## **Development Facilitation Team (DFT) – Review Comments**

**DRB Project No: PR-2020-003484 Date: 11/13/2024 Agenda Item: #5 Zone Atlas Page: E-10**

**Request: Replat of Lots 2 and 3 – create 19 lots from the existing tracts.**

### **Application For: SD-2024-00158 – EXTENSION OF PRELIMINARY PLAT (DHO)**

CITY OF ALBUQUERQUE
 PUBLIC WORKS DEPARTMENT
 ENGINEERING DEVELOPMENT GROUP
MOJAVE SUBDIVISION
 GRADING AND DRAINAGE
 GRADING PLAN

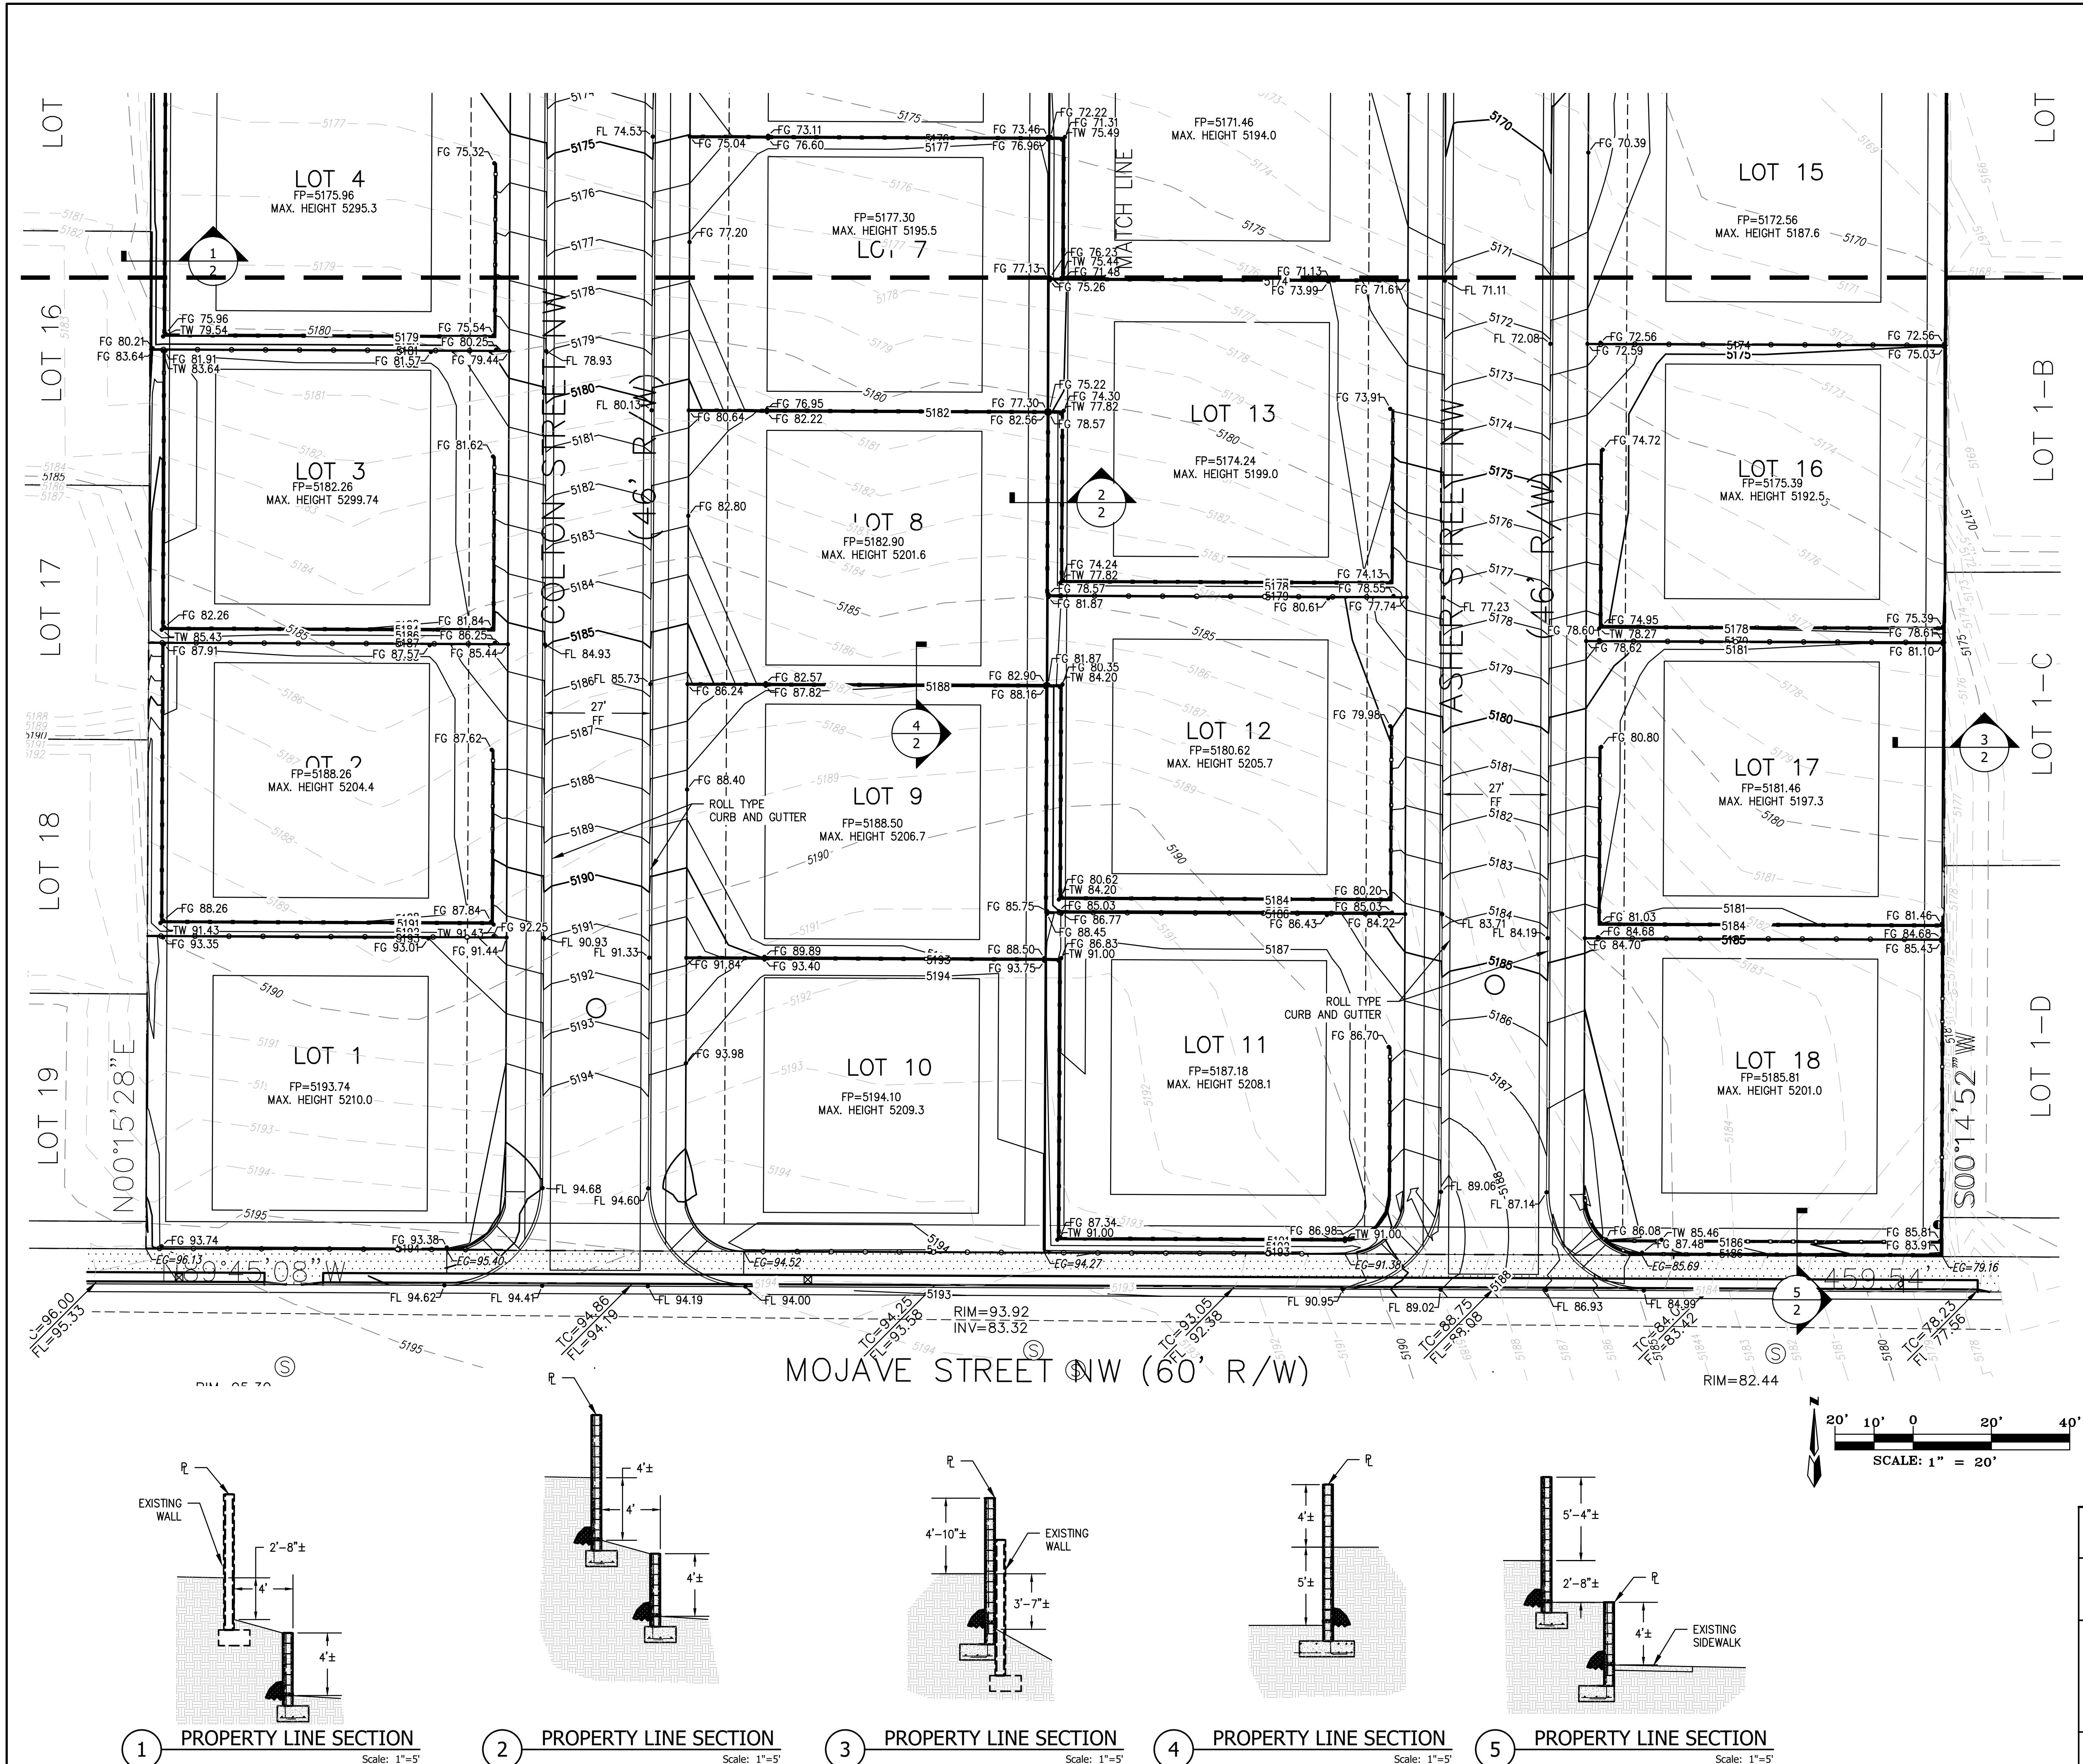
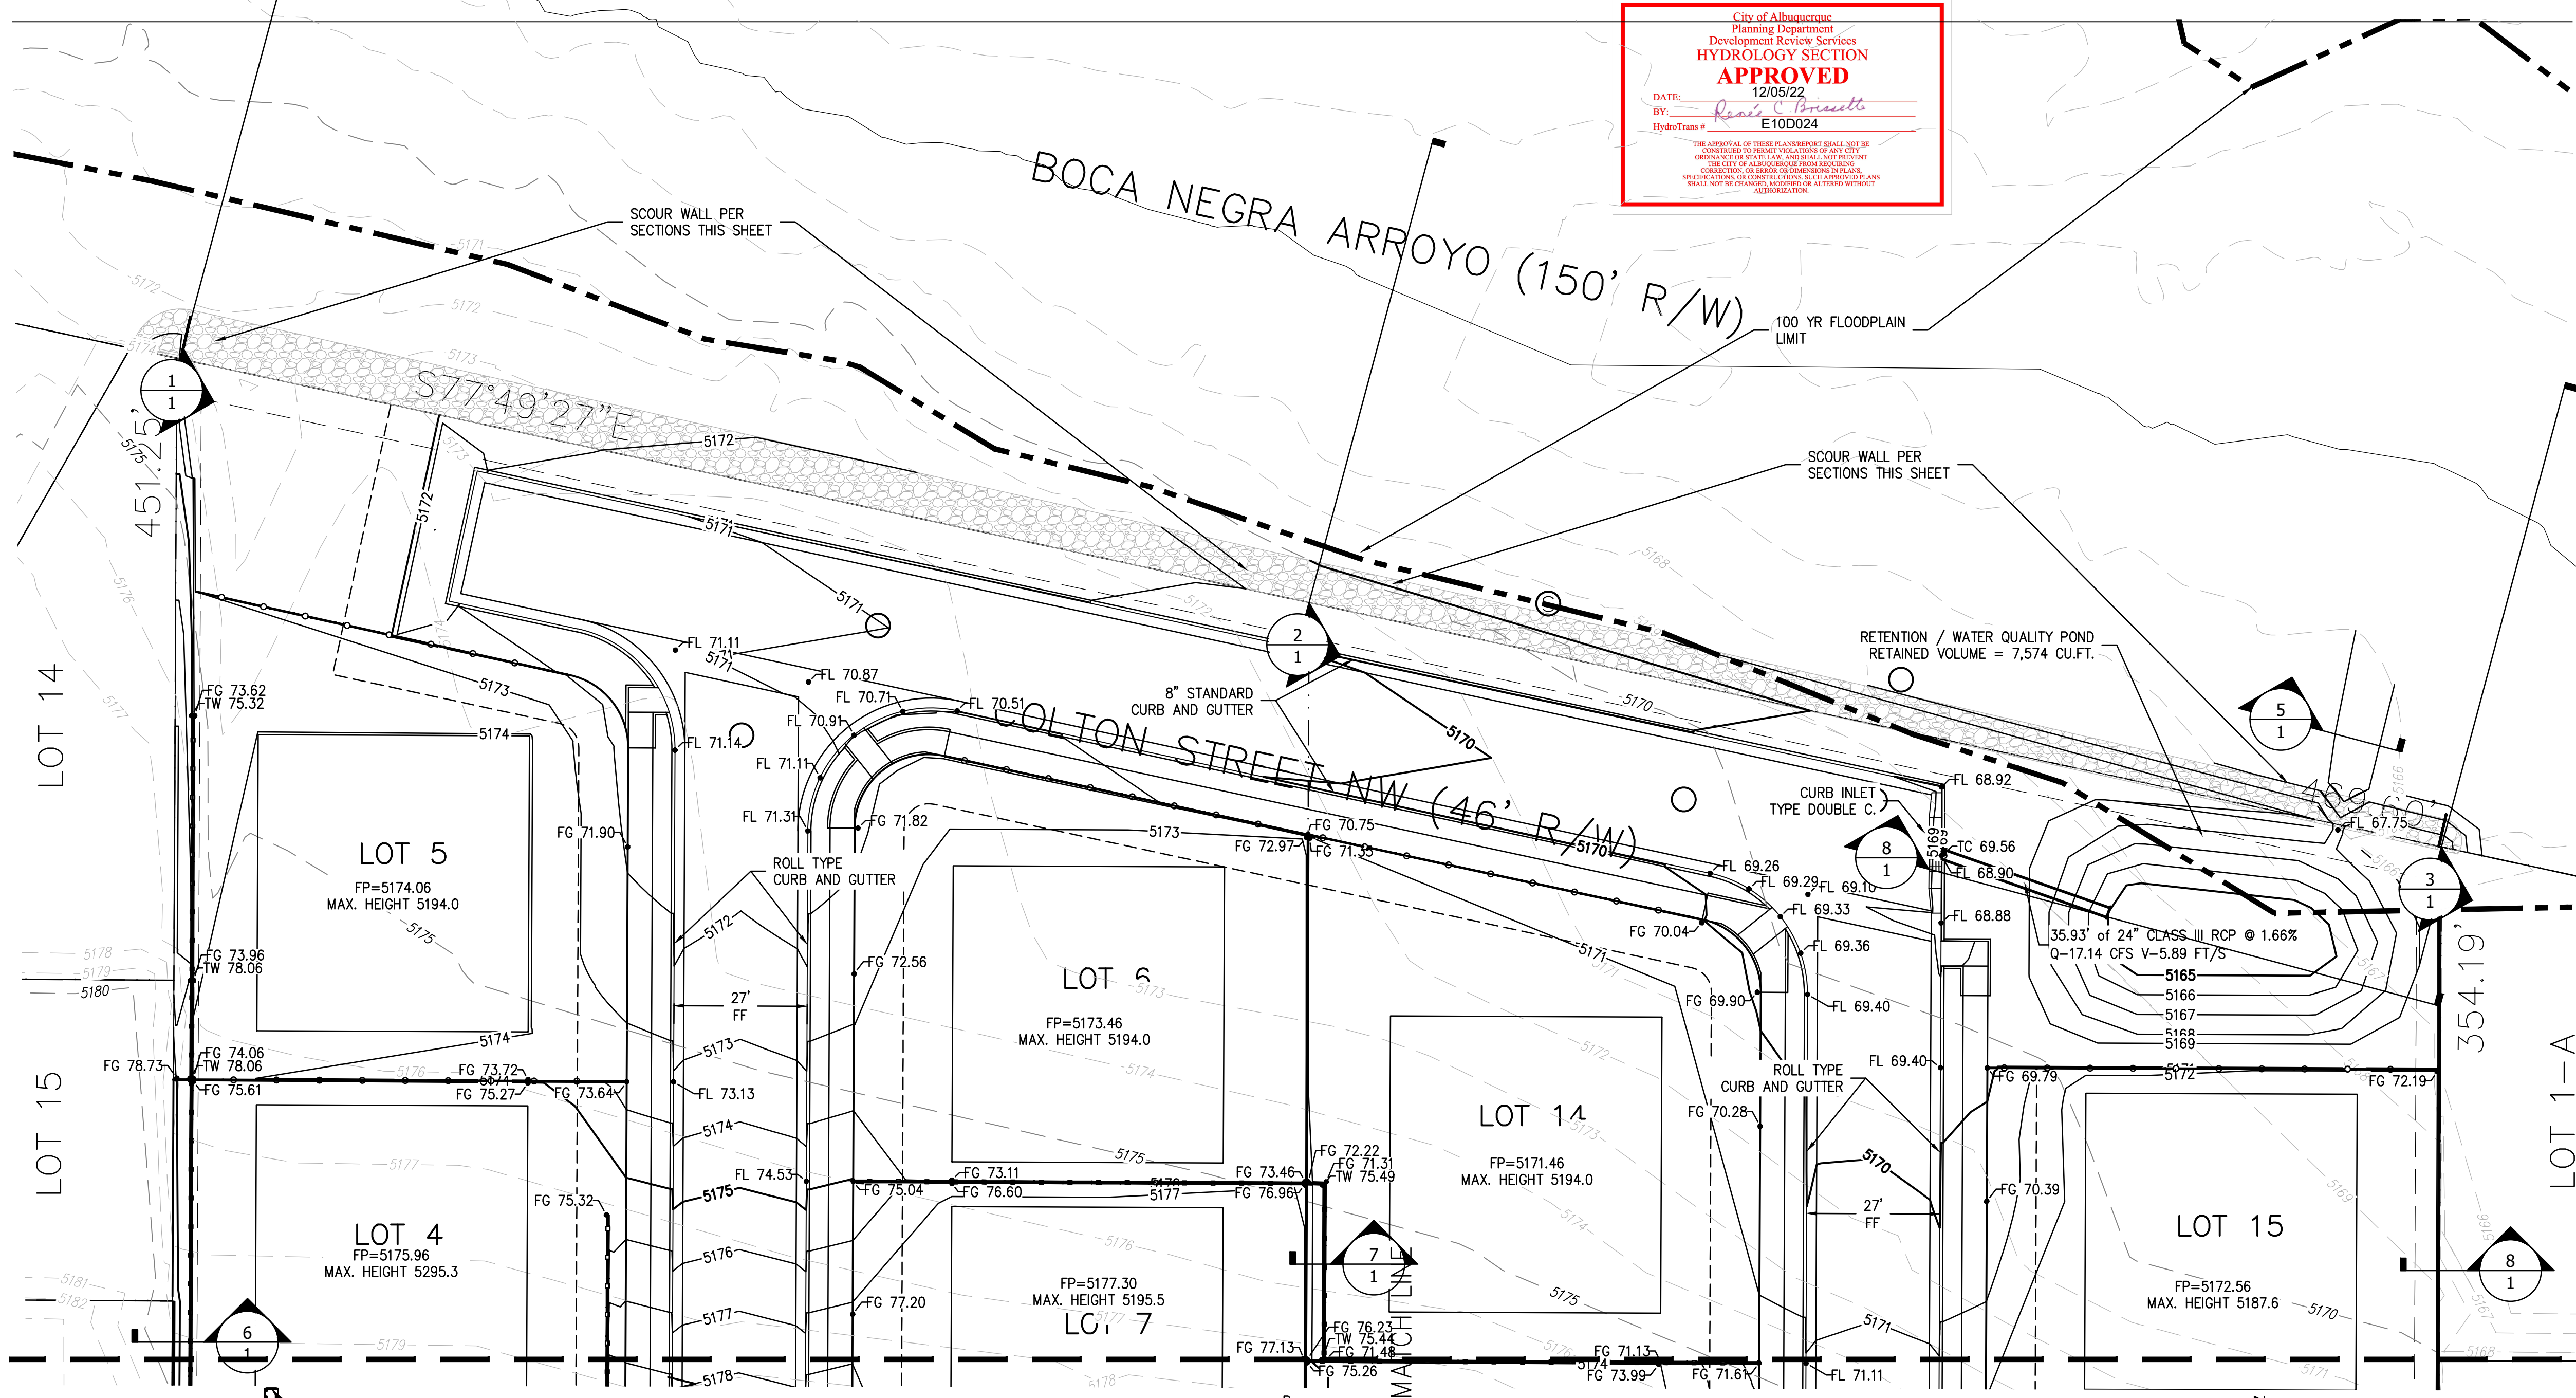
- 3. Pad sites on the Hydrology approved document must be corrected and limit the maximum height to 15 feet above natural grade as required in VPO-14-16-2 3-6(E)(3) Height restricted area*
